File ref: **SSD-78247462**

RE: SUBJECT CANYONLEIGH BESS PROJECT SSD-78247462
962 Canyonleigh Road, Brayton

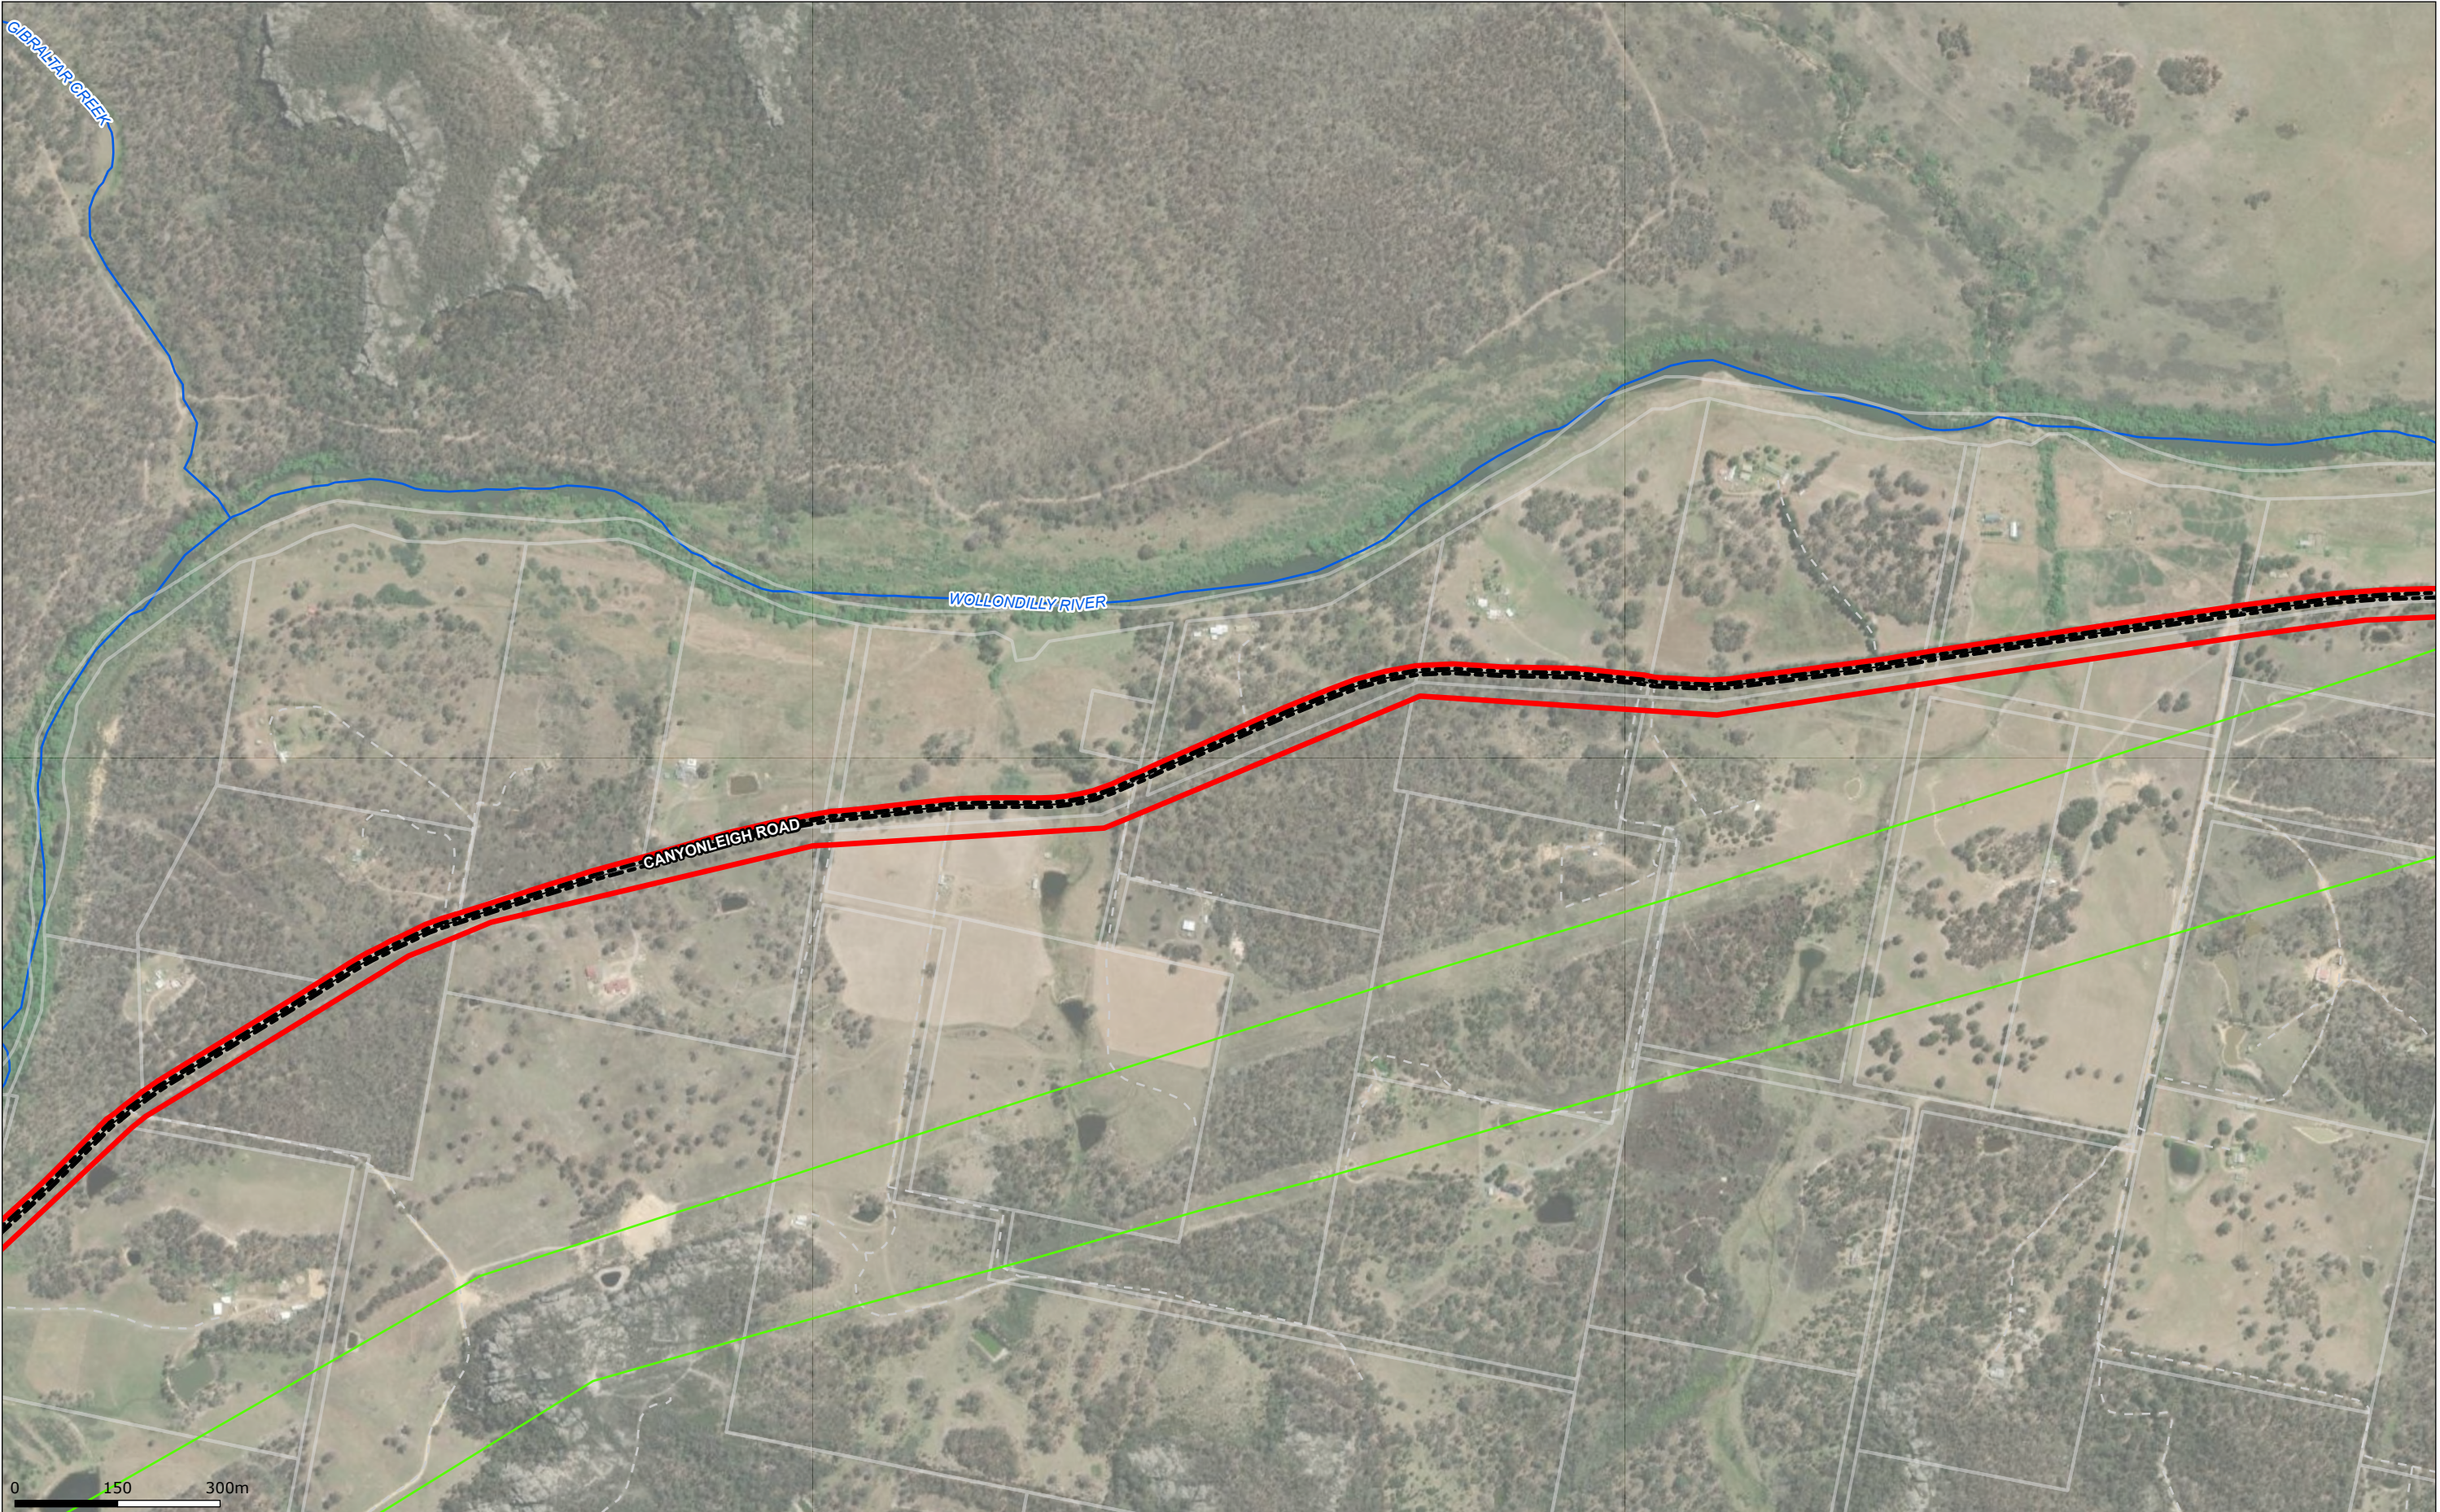
- The detailed plans do not indicate scaled elevation plans or proposed height of the different elements – it is considered this is a vital impact to allow comment and submission on. Will the BESS containers be single level and to what height?

- Most of the plans indicated Dairy Road to the east of the development site. This is not correct. The land to the east is accessed via a private road and not Dairy Road. Dairy Road is located approximately 2.4km west along Canyonleigh Road. This matter needs to be corrected to avoid confusion and access along the unnamed private access.

DEVELOPMENT FOOTPRINT (21.6 Ha)
PROJECT AREA

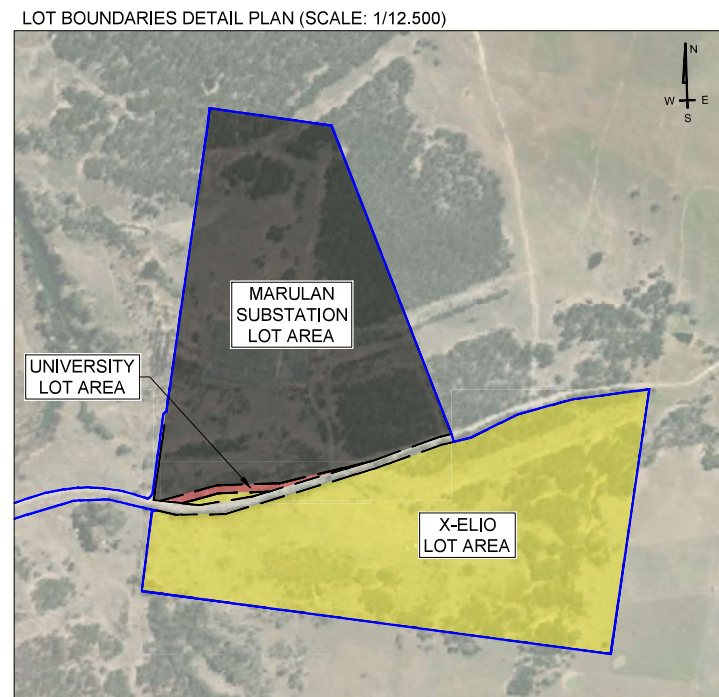
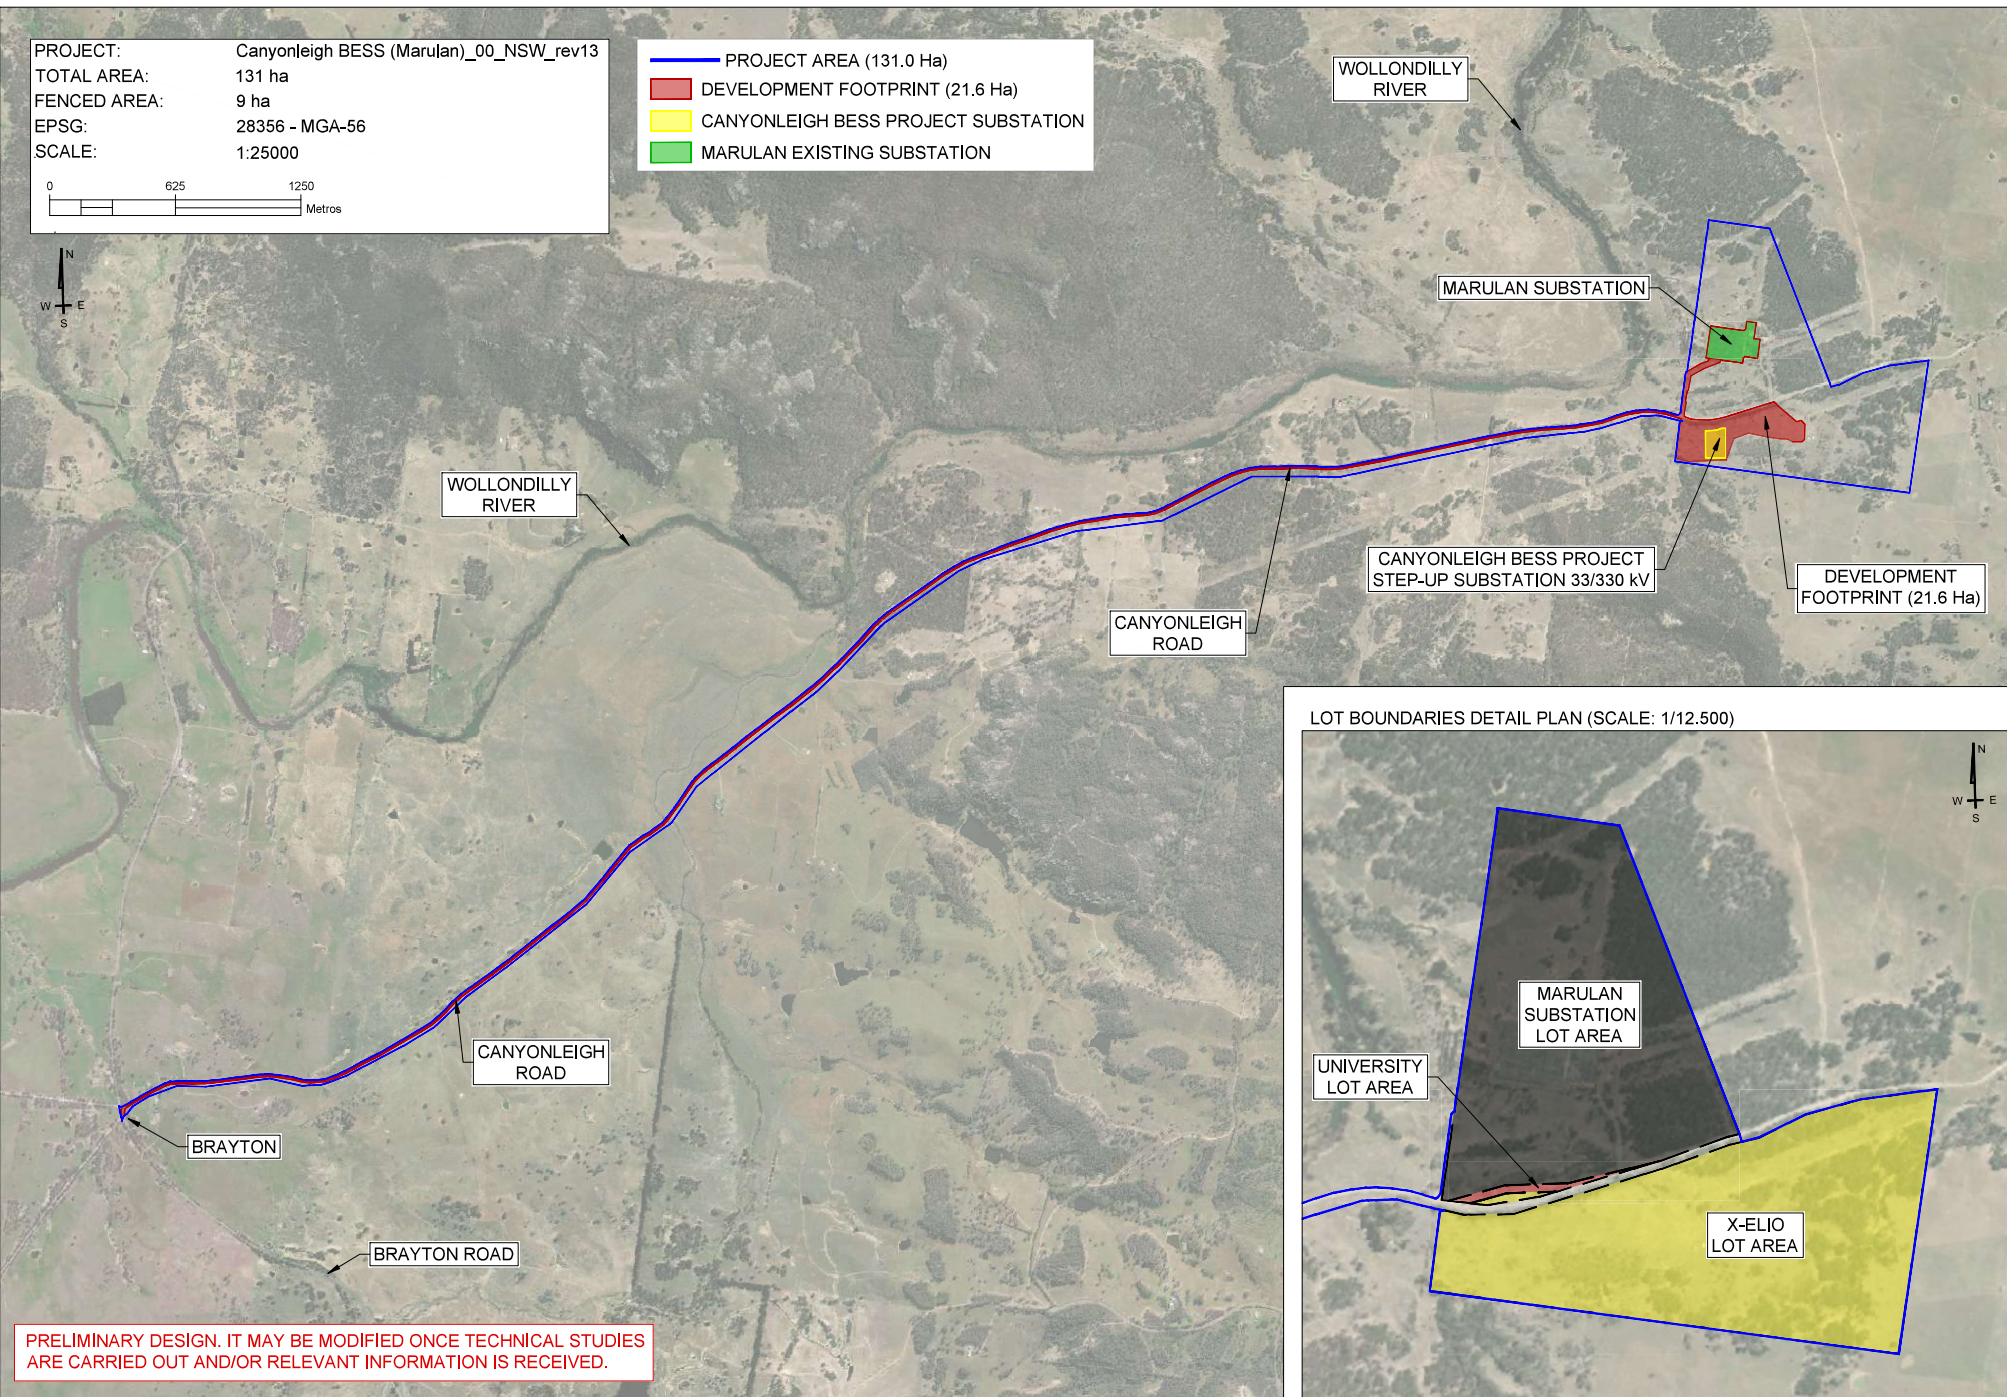
- The Bush Fire Assessment states “The internal roads will provide adequate access to the site, including the BESS units, for emergency vehicle access.”(S5.2). It is argued that the eastern most arrangement does not meet this standard as an access/maintenance road is not proposed north, south or east of the arrangement as shown in the below extract (green bold circle). It is recommended that the eastern most arrangement be deleted from the design if the project is approved.
